October 27, 2017

RE: **Signal Village Condos**
Grading Plan
Engineer's Stamp Date 10/03/17
Hydrology File: C20D077

Based on the information provided in the submittal received on 10/04/2017 the above-referenced Grading Plan cannot be approved for Preliminary Plat, Building Permit, or Grading Permit until the following are addressed:

FIGURE 6
LA CUEVA CHANNEL LOMR
ANNOTATED FIRM

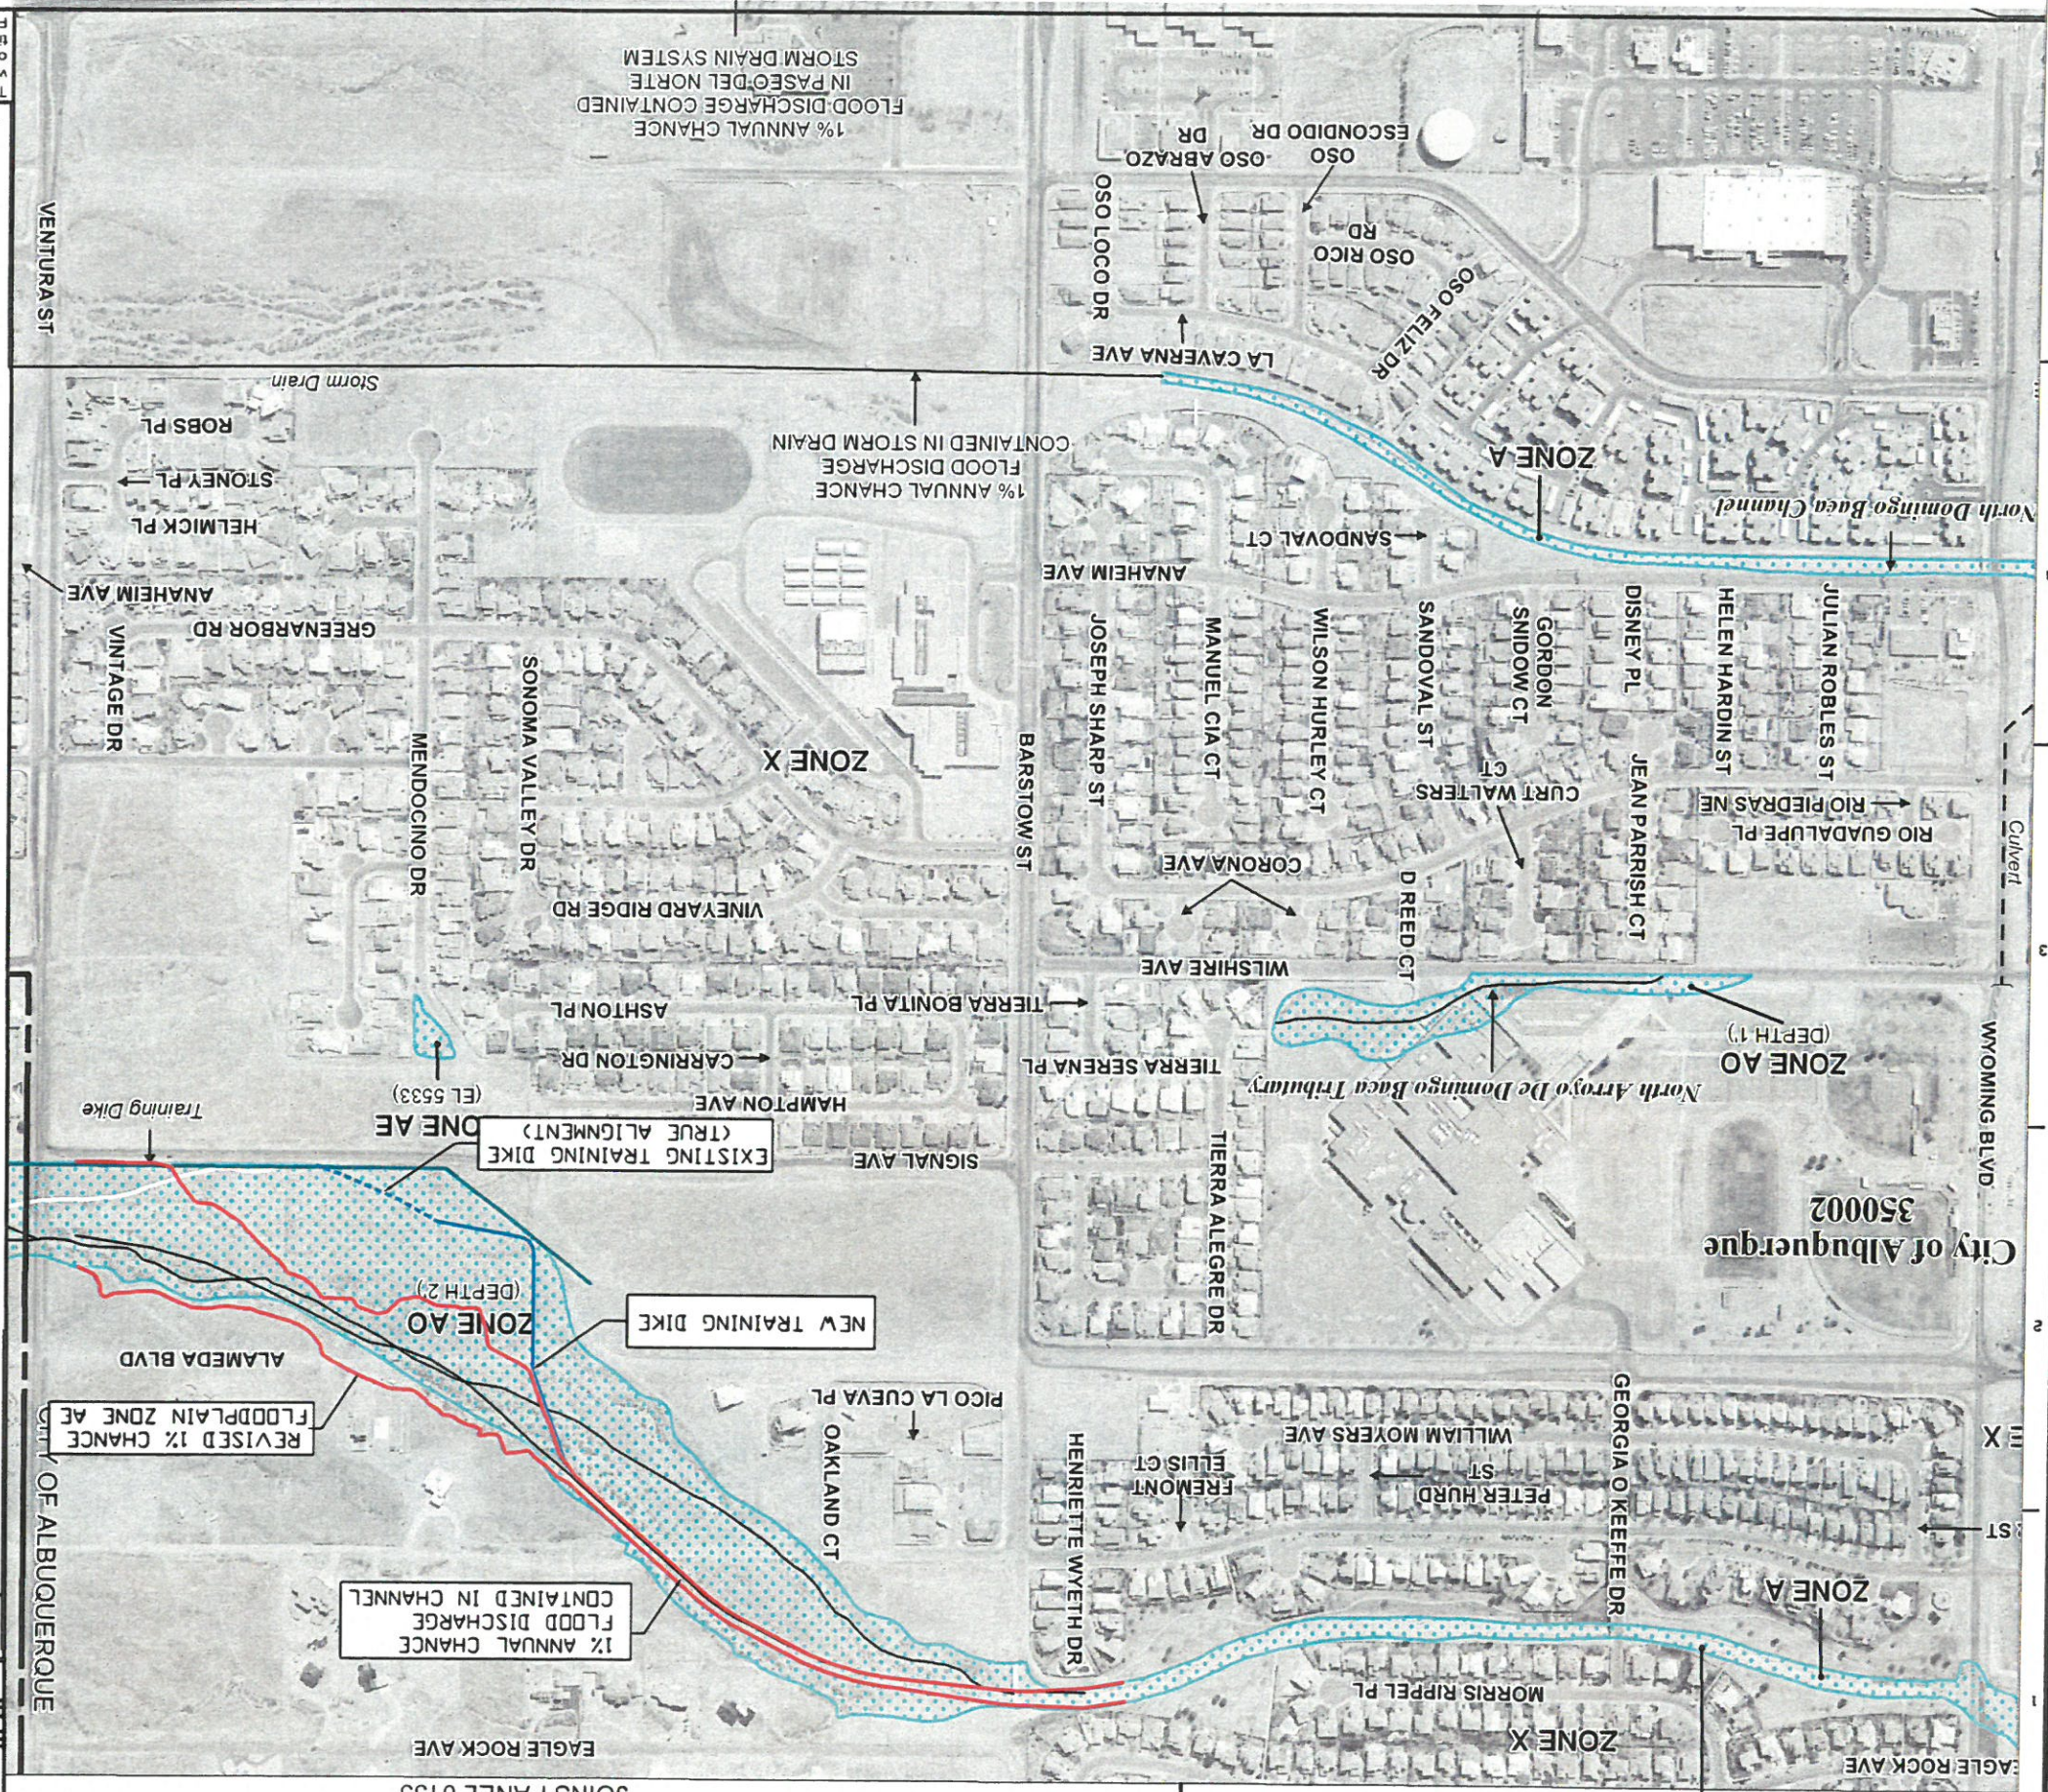
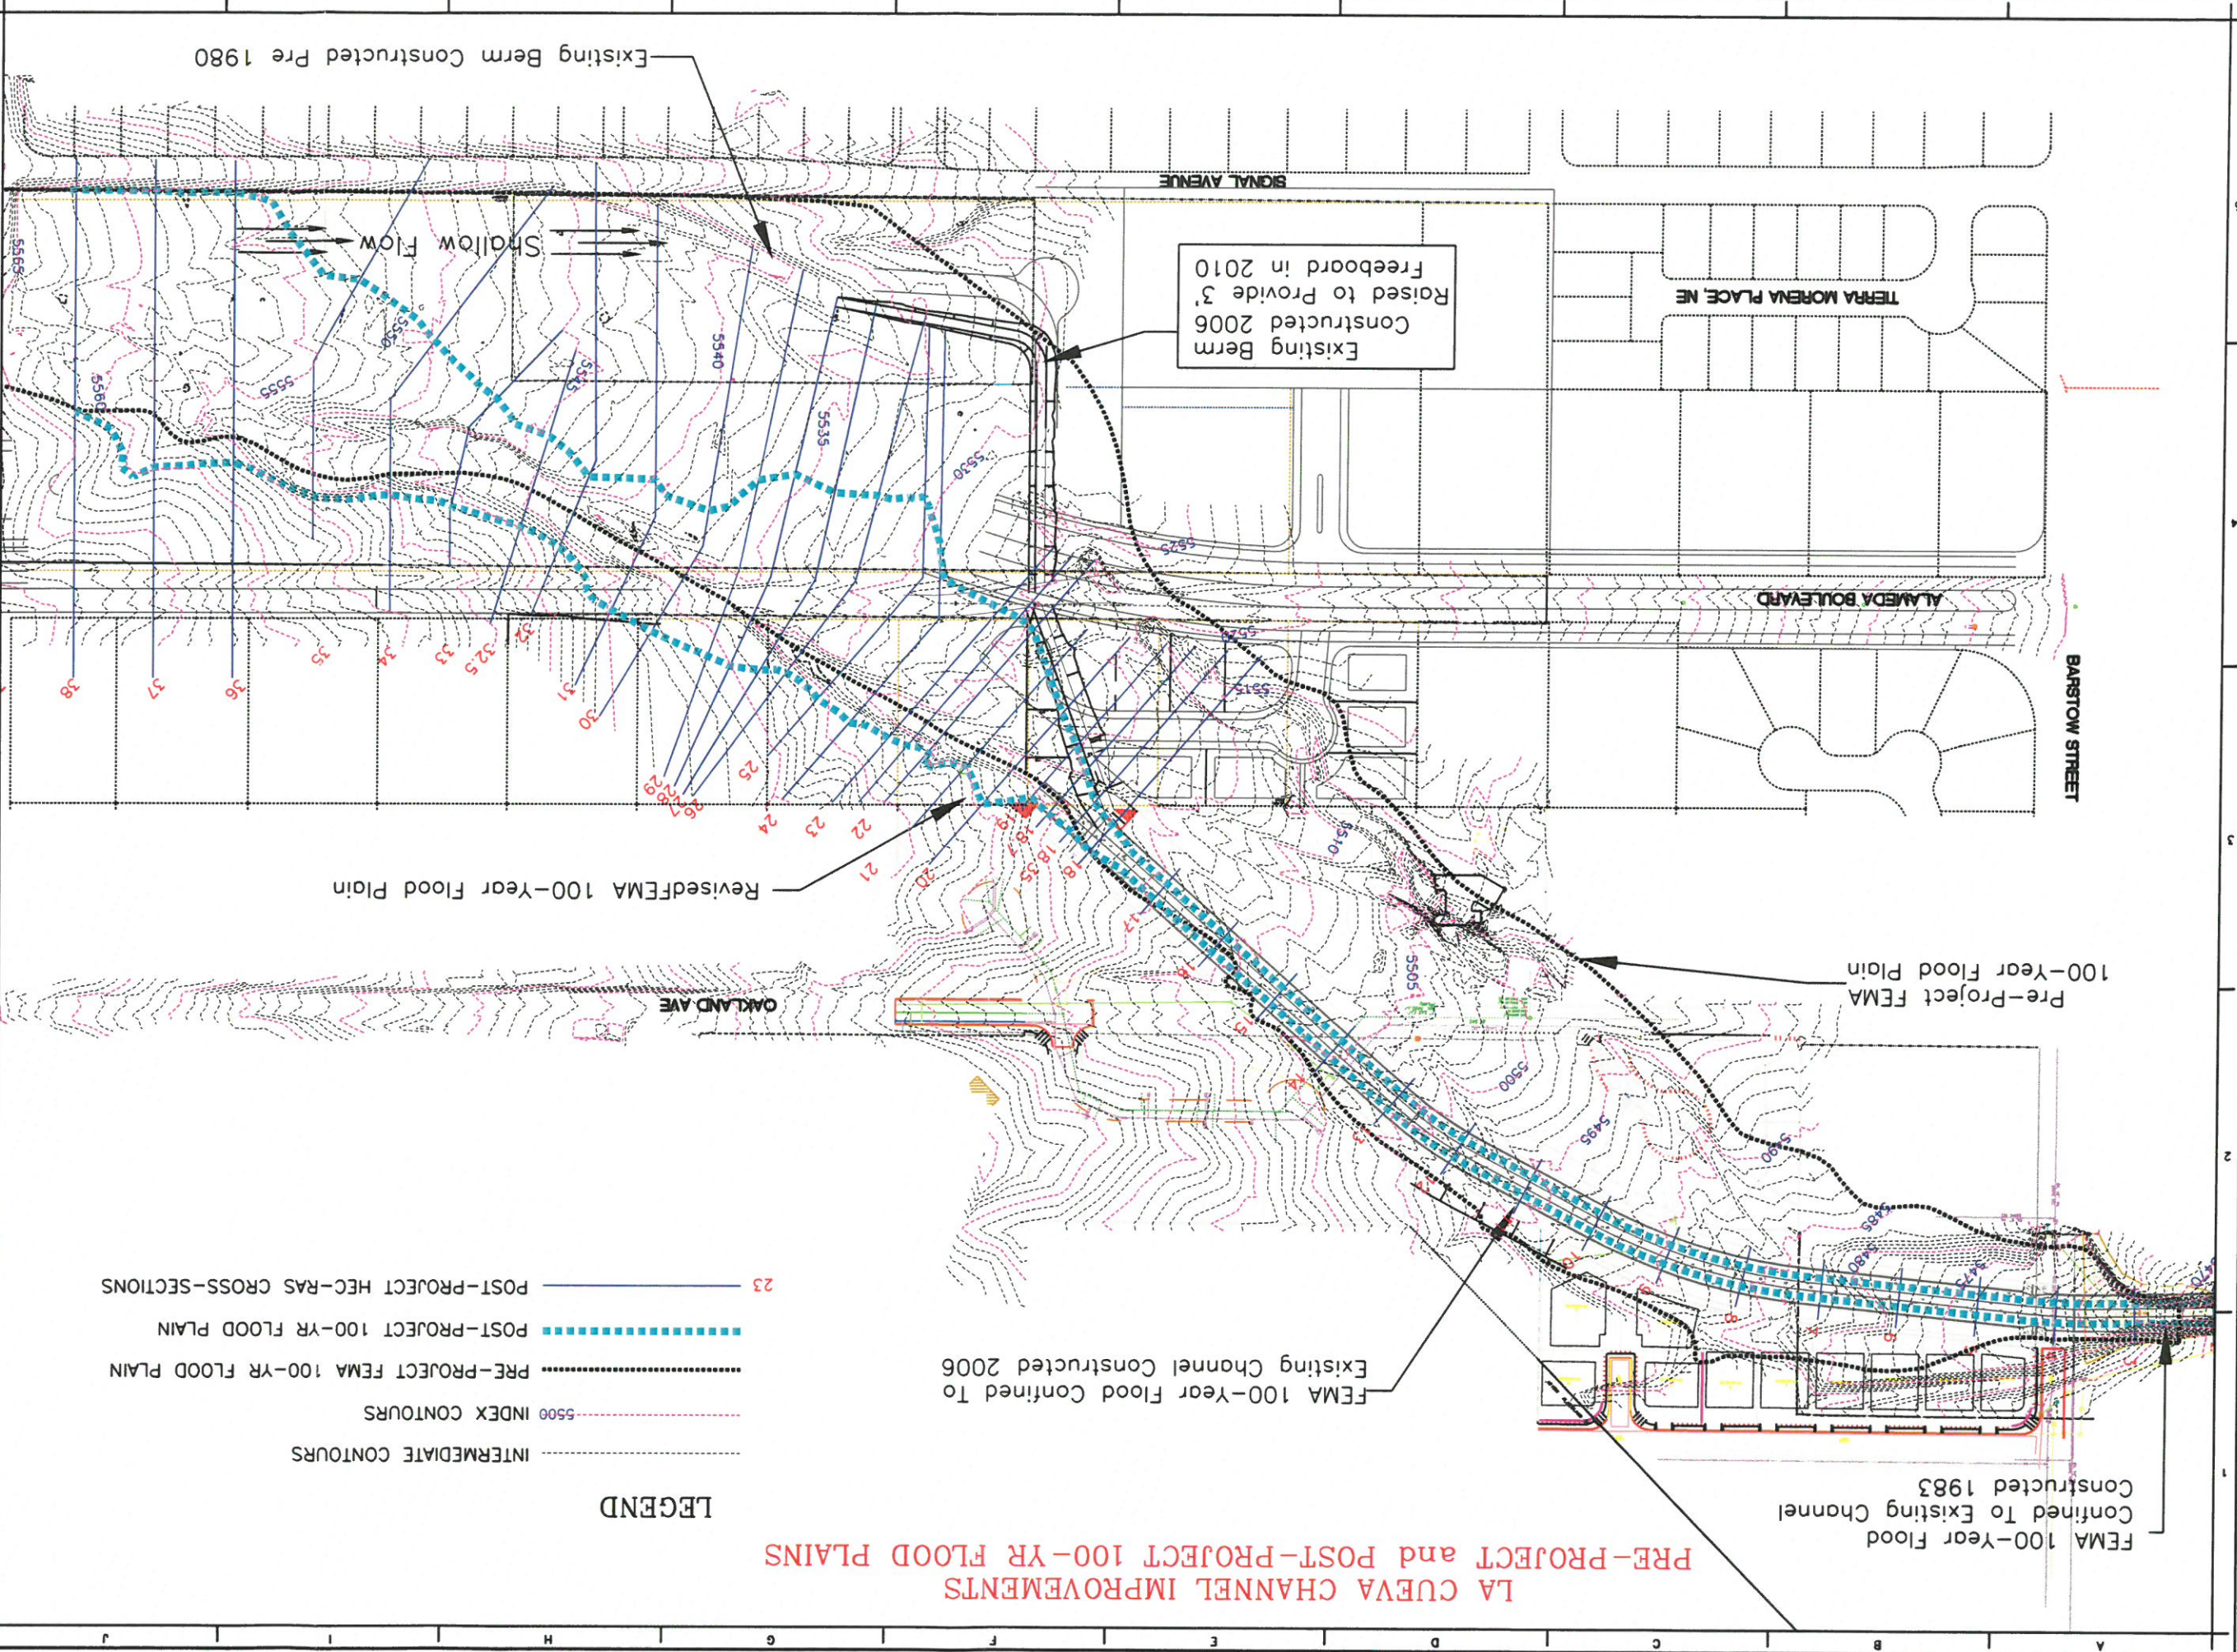
9. What is a "Monolithic Pad"? Is it a concrete slab or is it a dirt pad?
10. The location of the FEMA floodplain and related information is not shown accurately on this G&D Plan or on other recent plans, Signal Point and 9000 Alameda. FEMA's location must be accurately shown on this plan and a note should be added referring to the effective date and FEMA file number. The FEMA thalweg and sections should also be shown.
